Our Ref: AB/63/20/DOC

Approval of details reserved by condition imposed under ref AB/60/17/PL relating to Condition Nos 3 - materials & finishes, 4 - site set up, 7 - vehicular access onto Canada Road, 8 - vehicular access and 9 - surface water drainage.

74-76 Canada Road Arundel BN18 9HY

Condition Number 7

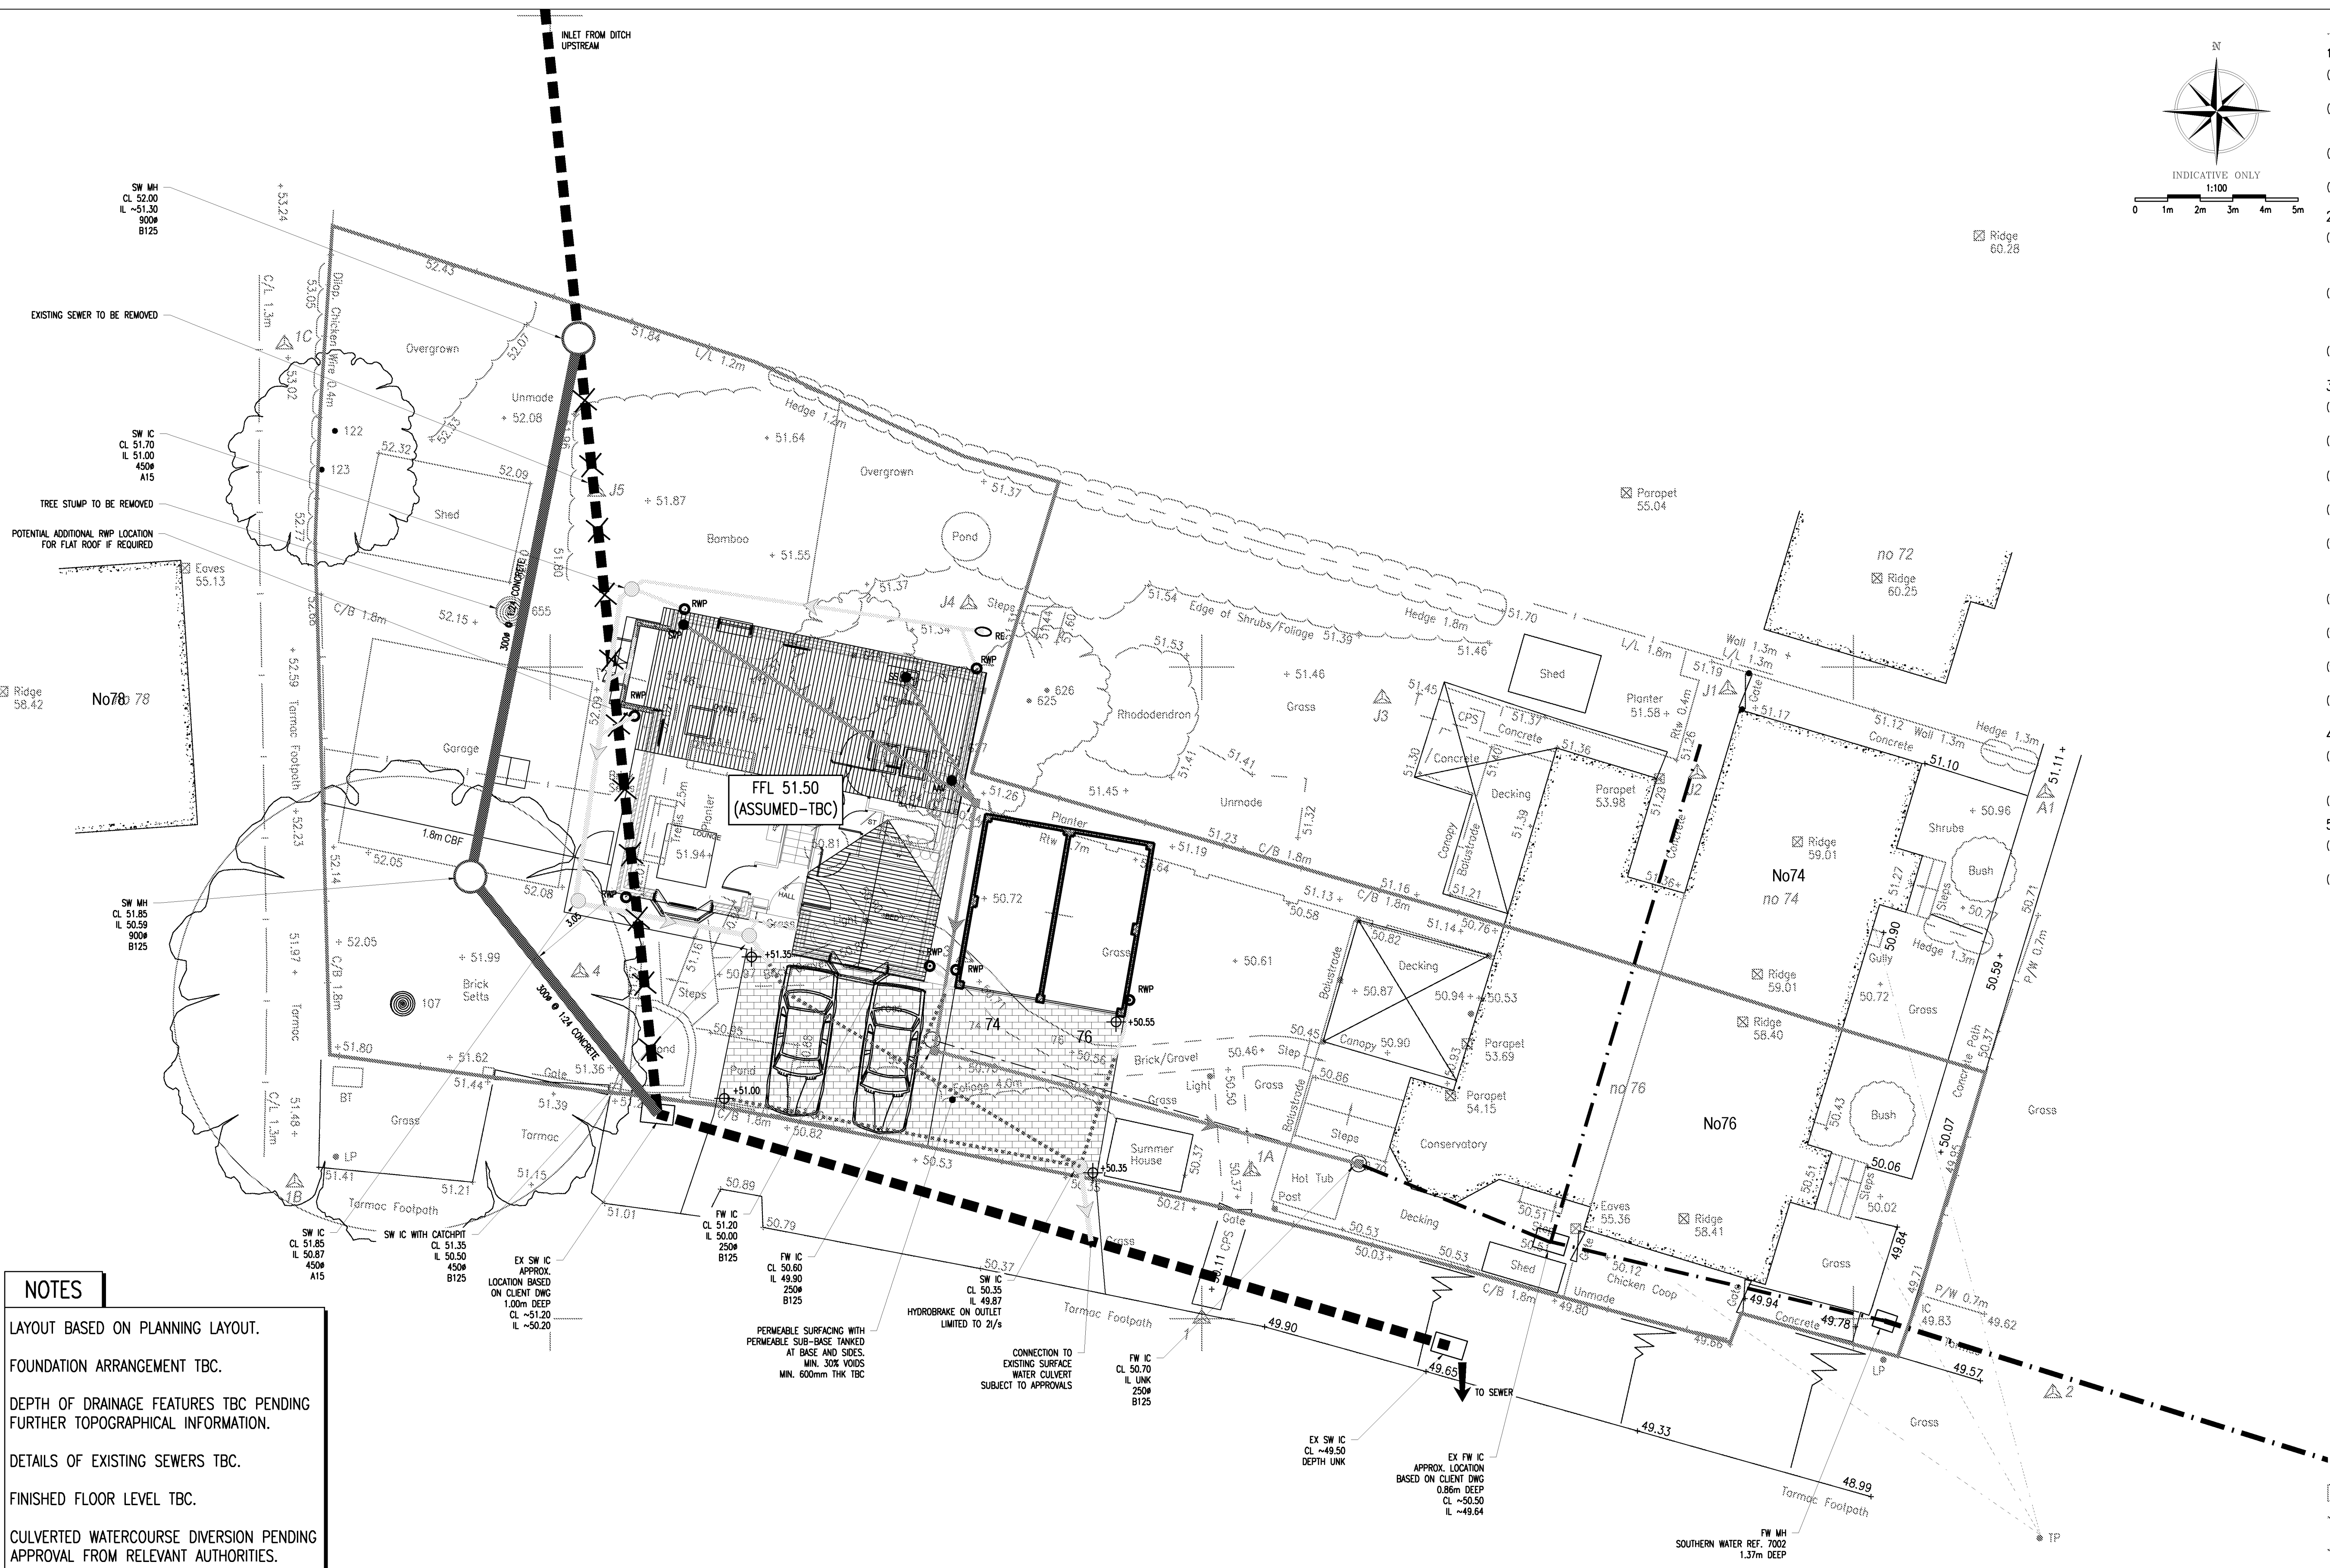
This condition is discharged in so far as submission of details relates and refers to the closure details indicated on drawing 15718-HOP-ZZ-XX-DR-C-10001-P1.

However it should be noted that this plan is only approved in this respect and discharge of this condition does not imply the other crossover details on the drawing are acceptable.
